Appeal Decision

Appeal Ref: APP/R5510/W/21/3283796

Land rear of 140-142 Green Lane, Northwood HA6 1AN

- The application sought planning permission for "Two x 2-storey, 3-bed dwellings with habitable roof space, parking and amenity space and single storey cycle shed" without complying with a condition attached to planning permission Ref 73184/APP/2017/3359, dated 5 December 2017.

REV	AMENDMENTS	DRAWN	CHKD	DATE
Job Title 140 – 142 GREEN LANE, NORTHWOOD				
Client RIVERGATE HOMES				
Drawing Title SWEPT PATH – MEDIUM CAR				
Scale	Date	Designed	Drawn	Drawing No
1:200 @ A3	16 JUNE 21	DFM	DFM	21.90 – 001

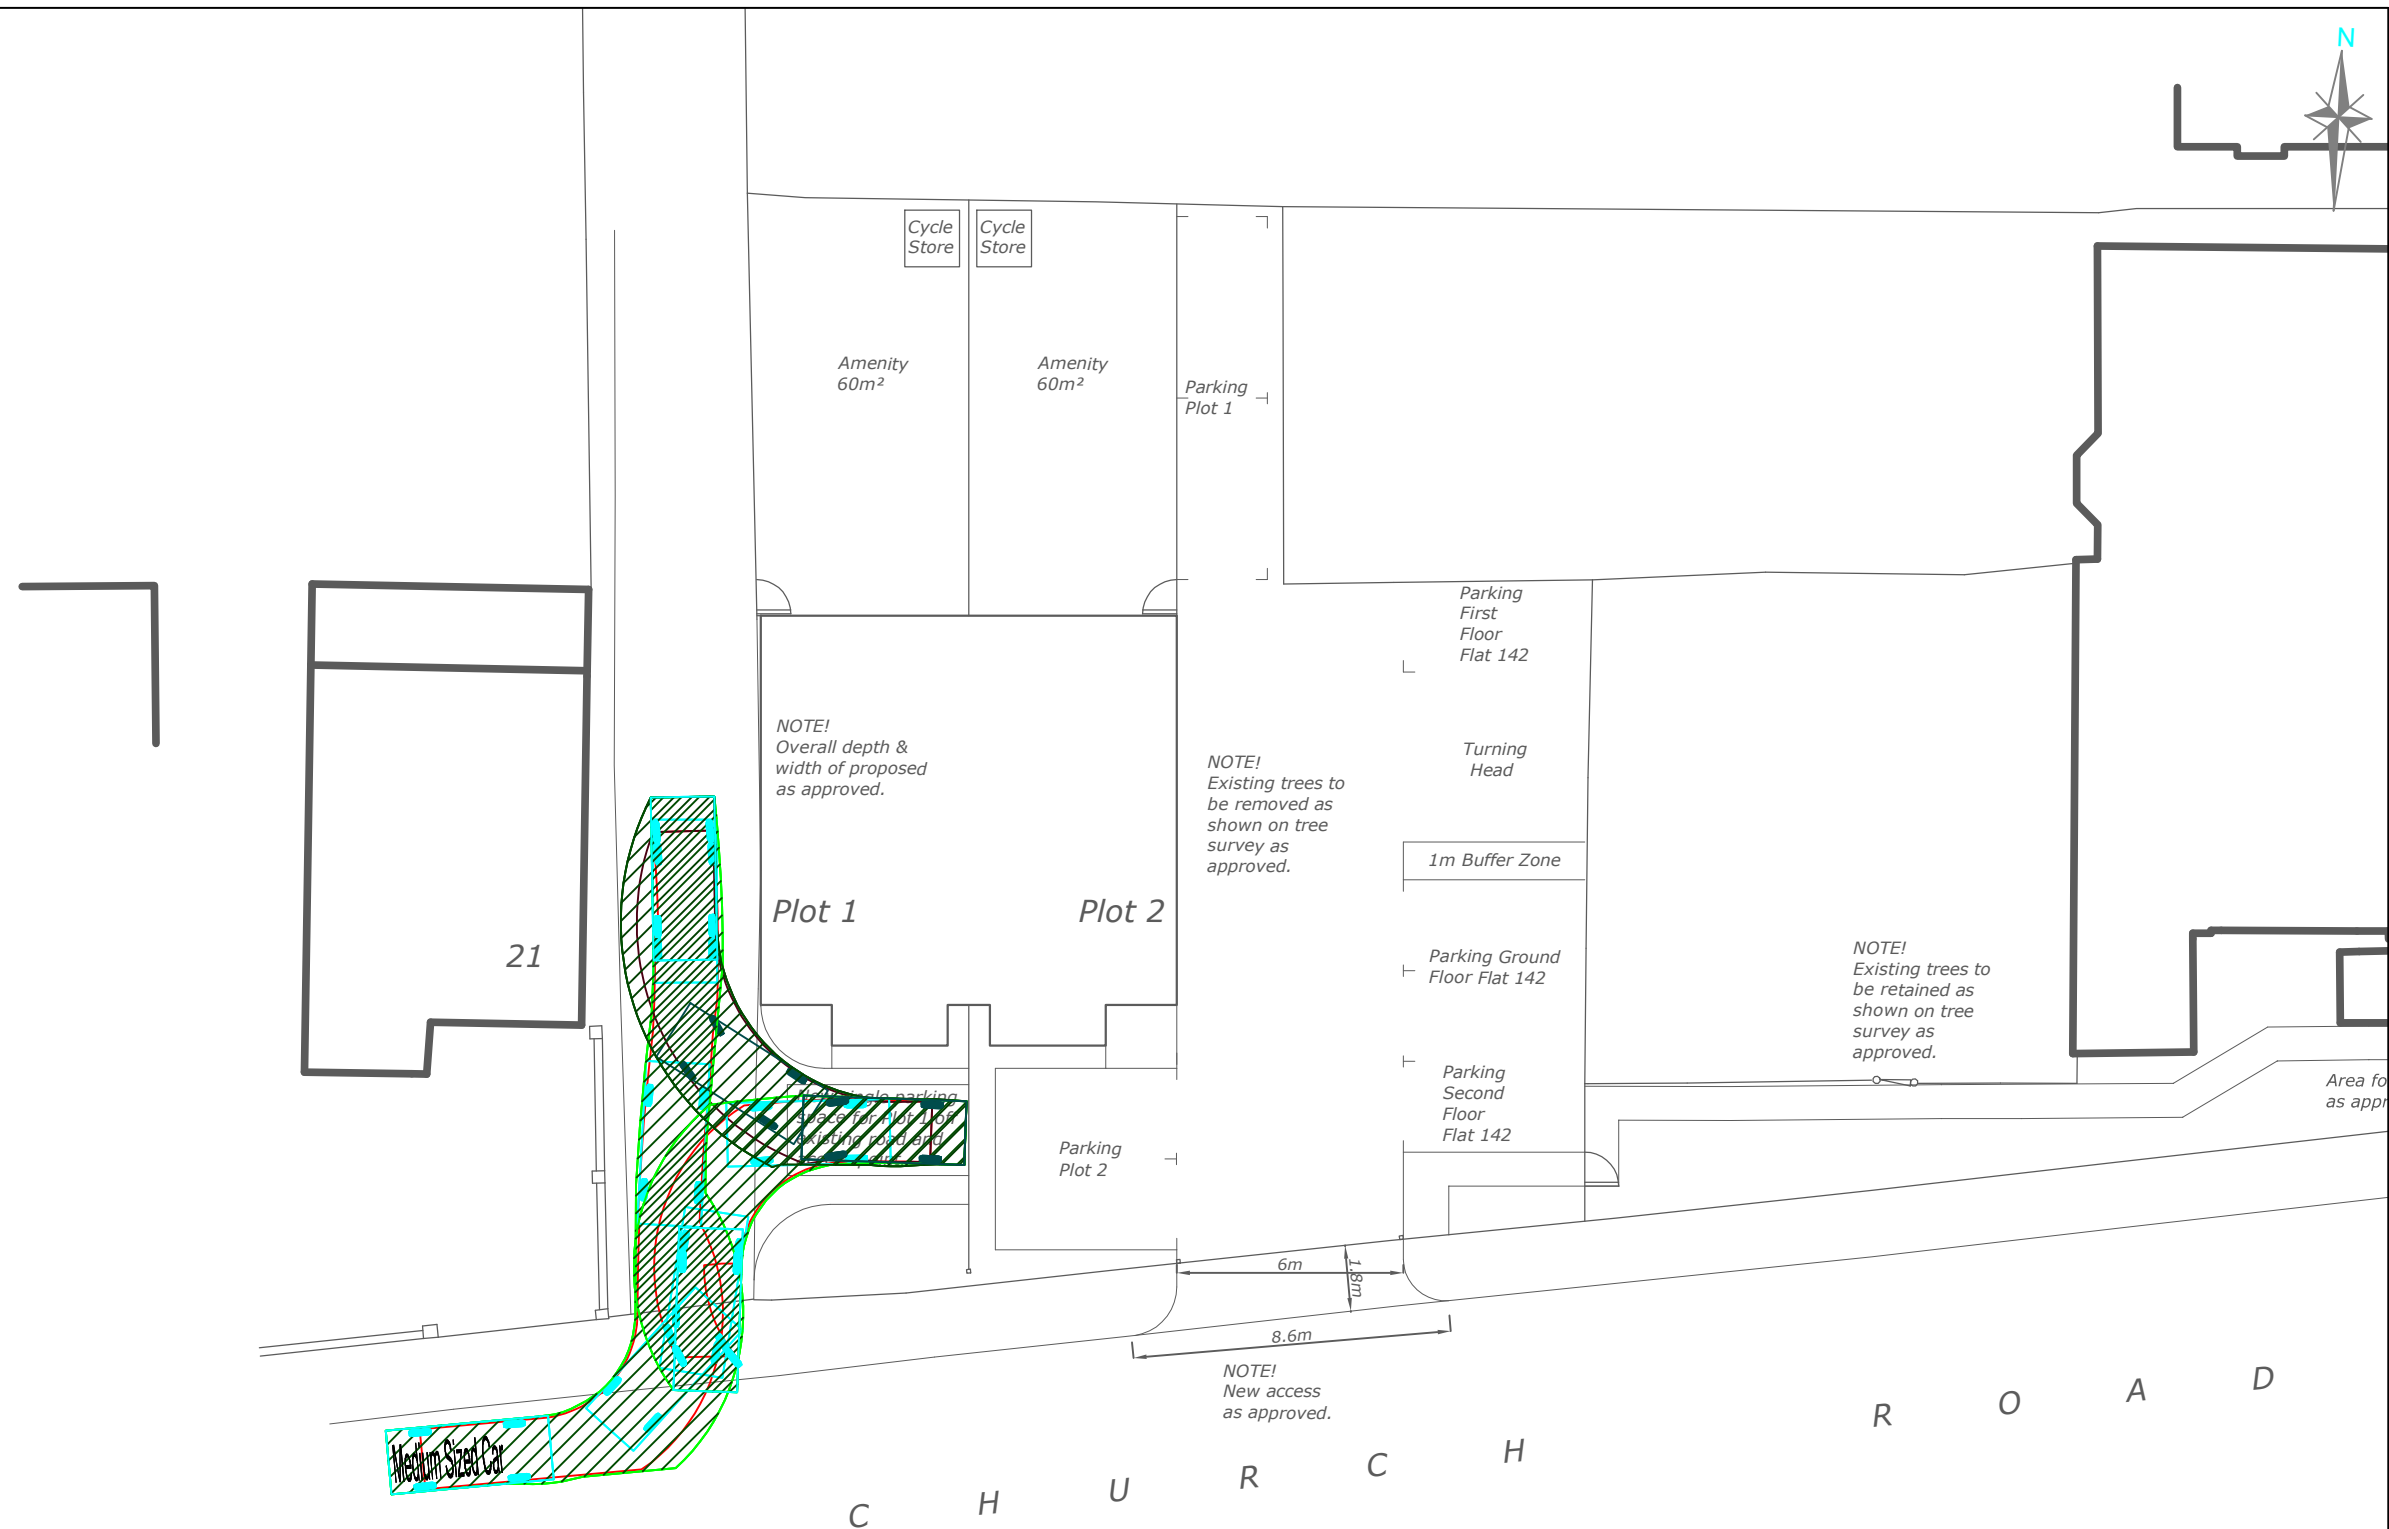
9. The appellant's submissions show that vehicles could enter and leave the site in a forward gear, by reversing onto the adjacent Pine Needle Lane, which is used by a number of residents of neighbouring properties. However, the appeal is not supported by detailed information to demonstrate that this private road is within the control of the appellant, or that he benefits from legal rights over it. Whilst no objection has been raised by the Local Highway Authority, the proposed arrangement would increase the risk of conflicts with other users of Pine Needle Lane, especially due to the lack of visibility which would be experienced when reversing onto this private road.

Drawing Number	17 / 3445 / 1	Revision	A
Date	13 / 3 / 17		
Scale	1:200 @ A2

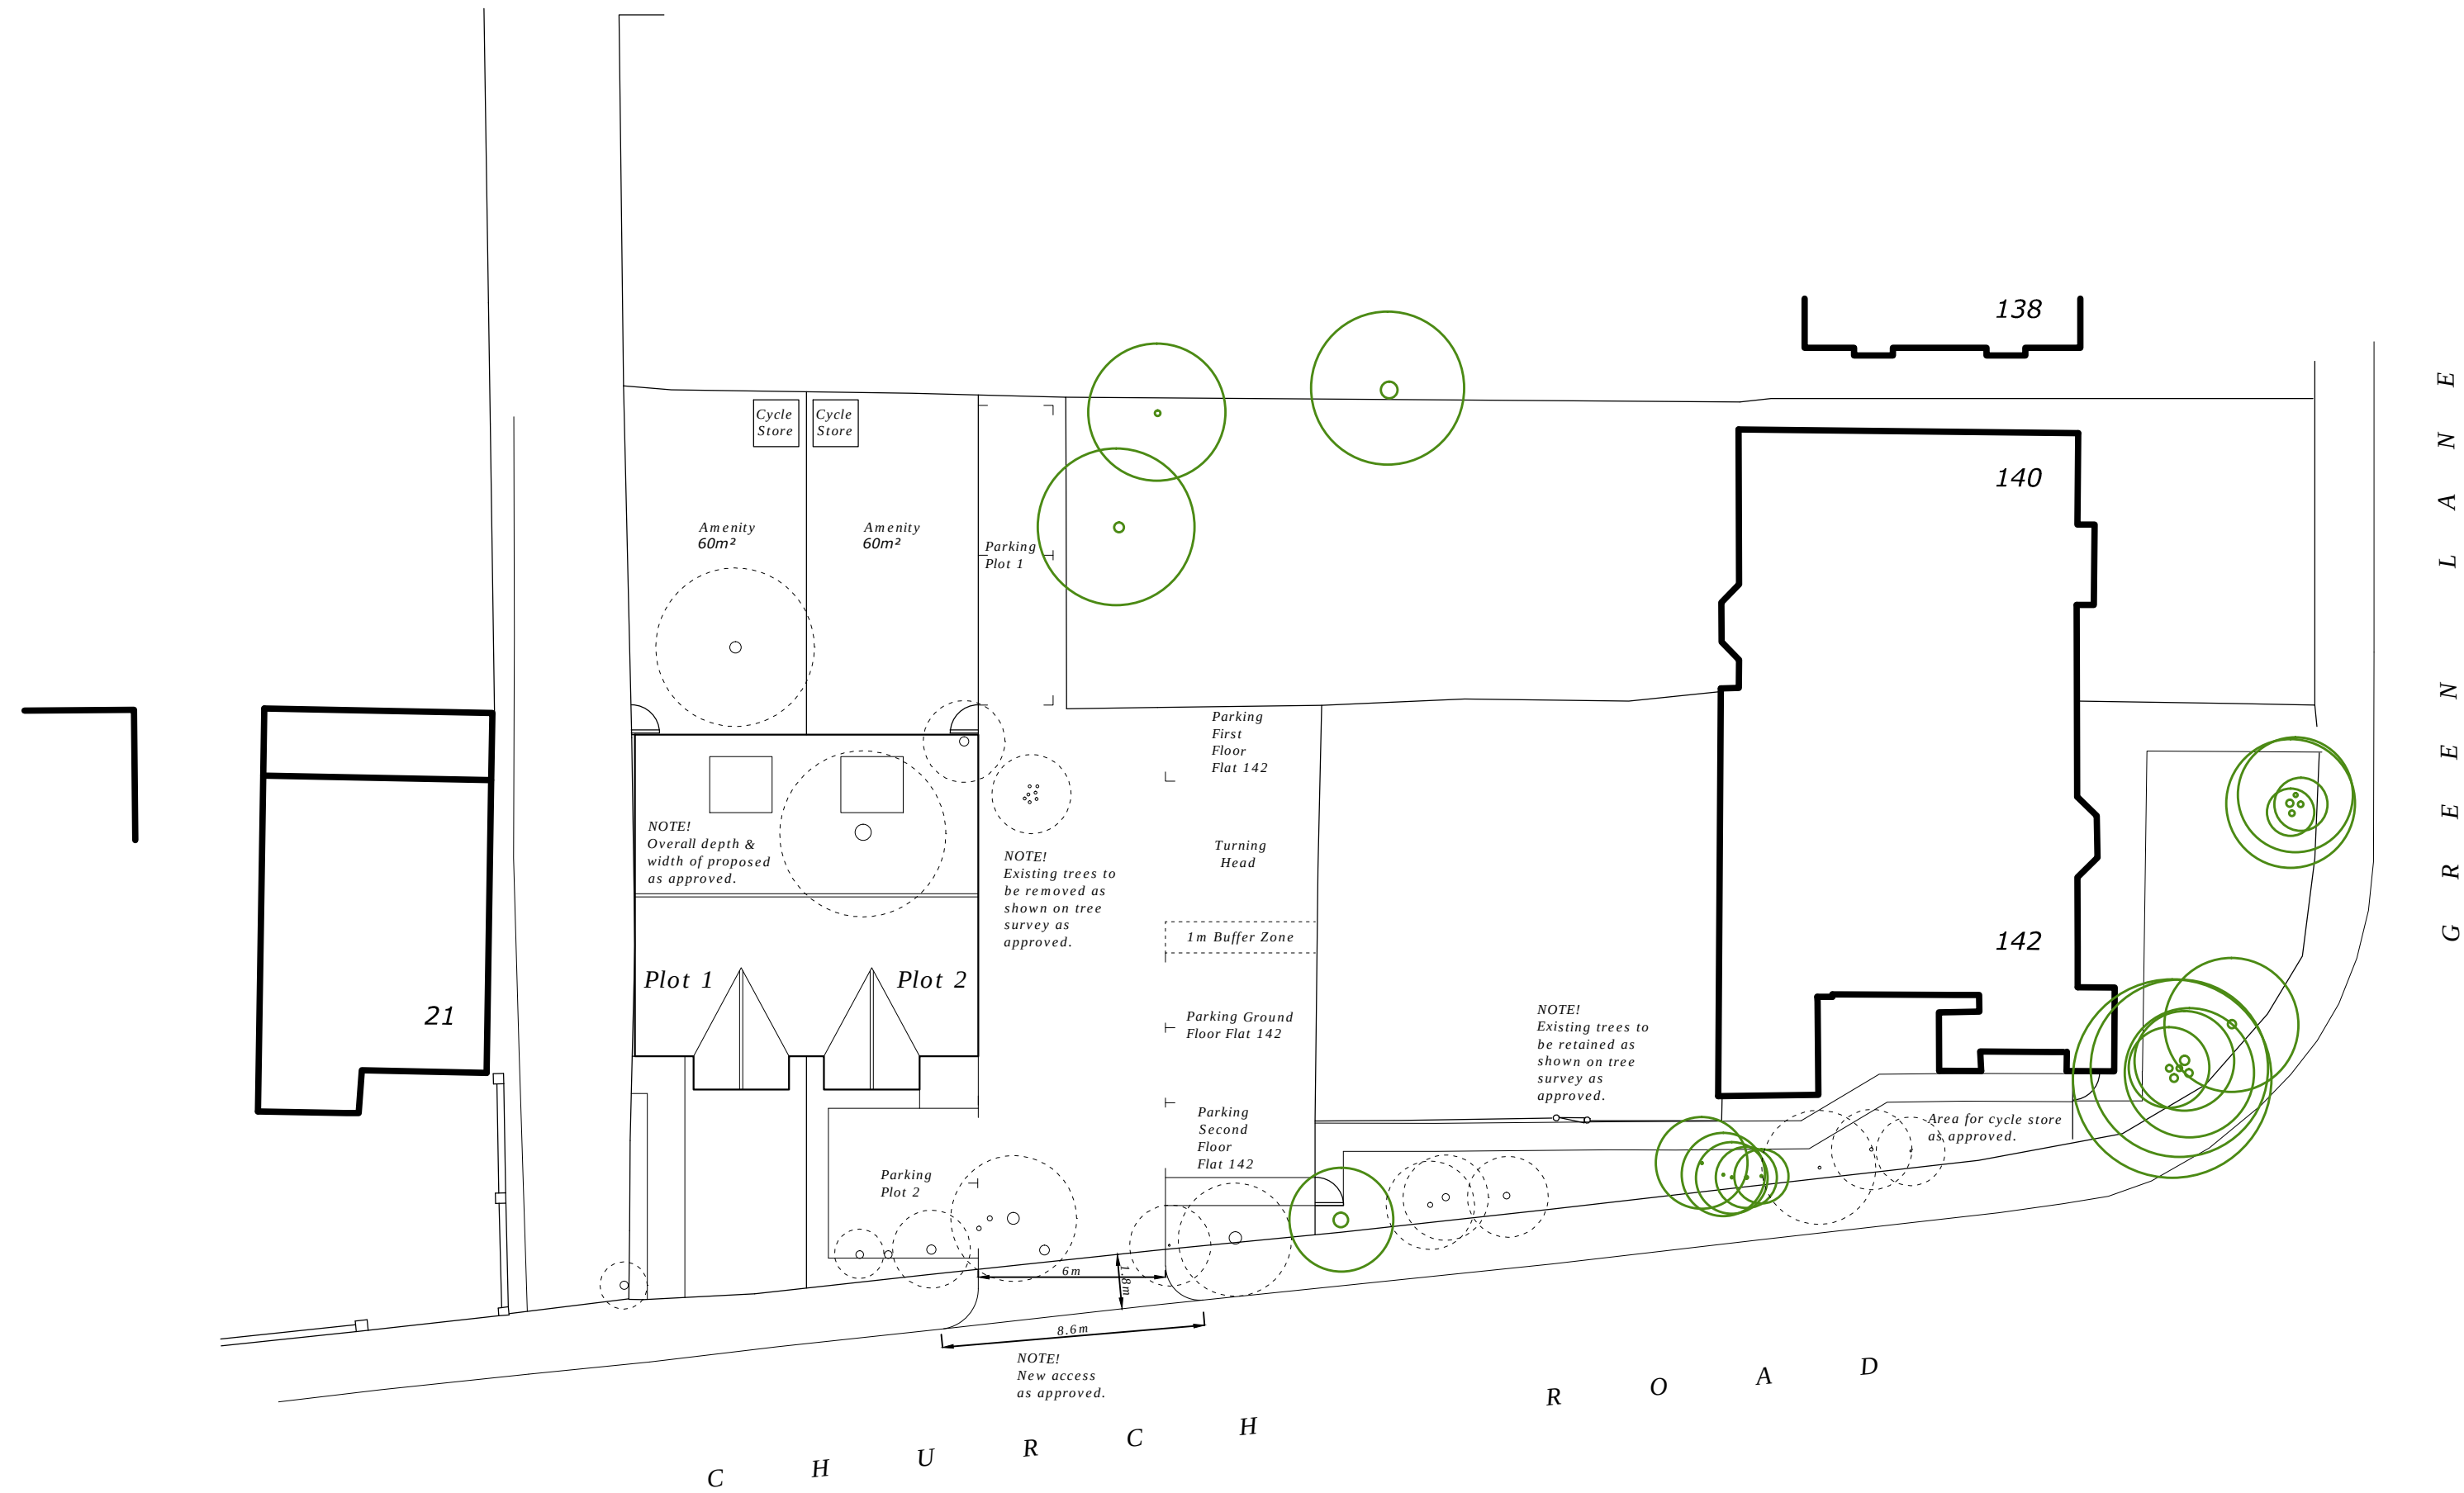
5. By reason of the modest size of the front garden, the creation of the proposed parking area would leave very limited scope for the provision of meaningful landscaping. In the absence of further details to the contrary, I find it unlikely that planting would be able to thrive in such a constrained area. The proposed parking area, together with the extensive hardstanding areas previously approved to the front and side of the dwelling on plot 2, would create a harsh environment, which would detract from the pleasant suburban character and appearance of the site's surroundings. It is therefore considered necessary to retain the area to the front of the dwelling on plot 1 as a landscaped front area to soften the visual impact of the development.

8. The proposed changes would enable the formation of a parking space to the front of the dwelling on plot 1. This would be in addition to the 2 parking spaces which were approved as part of the extant scheme. The siting of the additional parking space may be more convenient for the occupiers of the dwelling, but limited information has been presented to justify the increase in the overall number of spaces. The appeal site lies within an accessible area and in the absence of further evidence to the contrary, the overprovision of parking for a single dwelling would encourage use of the private car and fail to promote alternative, more sustainable modes of transport.
